Our ref: 19688

18 December 2019

RE: Submission – Sydney Gateway Road Project (SSI-9737)

Figure 6.11 Terminals 2/3 flyover access options

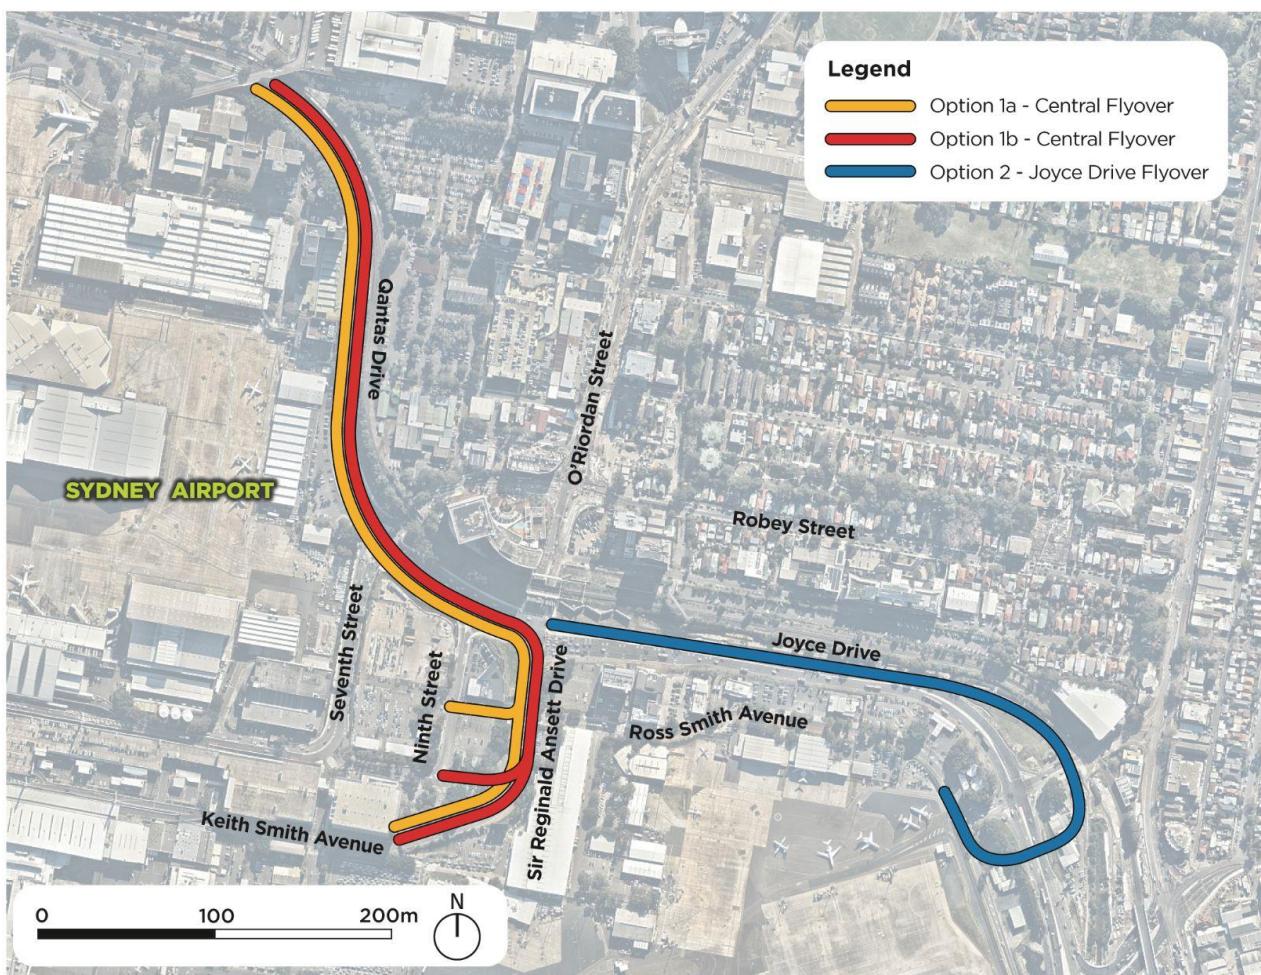
- + The proposed elevated overpass connecting Terminals 2/3 with the upgraded Qantas Drive terminates after the intersection of Sir Reginald Ansett Drive and Ross Smith Avenue. Consequently, a significant catchment of passing trade will not be in a position to access the businesses along Ross Smith Avenue in a convenient fashion.
- + The ability for east bound traffic on Qantas Drive to turn right into Sir Reginald Ansett Drive is unclear. Should traffic movement be restricted in this regard, it further restricts the ability for passing trade, including east bound motorists leaving Terminals 2/3 from being able to access the McDonald's via Sir Reginald Ansett Drive and Ross Smith Avenue.

Whilst acknowledging that future directional signage can be utilised, it is not considered that it is reasonable or practical to direct motorists leaving the airport, wishing to locate the McDonald's, to travel via Robey Street to O'Riordan Street. This alternative route is too disjointed and will cause confusion for cars. It is also not practical for cars utilising the overpass to have to circulate through the Terminal, back onto to the road network to access the McDonald's.

- + The existing right hand turn from Qantas Drive into Sir Reginald Ansett Drive be maintained. The congestion currently experienced at this intersection will be alleviated by the creation of the overpass. It is considered that this right hand turn can be maintained in the amended traffic environment.

- + Consideration should be made to providing a direct access from Joyce Drive for the existing restaurants in the Ross Smith Avenue precinct.
- + Consideration should also be made for a direct exit from the overpass road onto Ross Smith Ave. The projected overpass road feeds into the Domestic terminal via a series of ramps which feed traffic directly to different sections (Car Park; Arrivals; Departures etc) however there is no opportunity to access Ross Smith Ave. Ross Smith Ave has two hotels in addition to the freestanding restaurants and it is important to provide vehicles an opportunity to access Ross Smith Ave via the overpass.
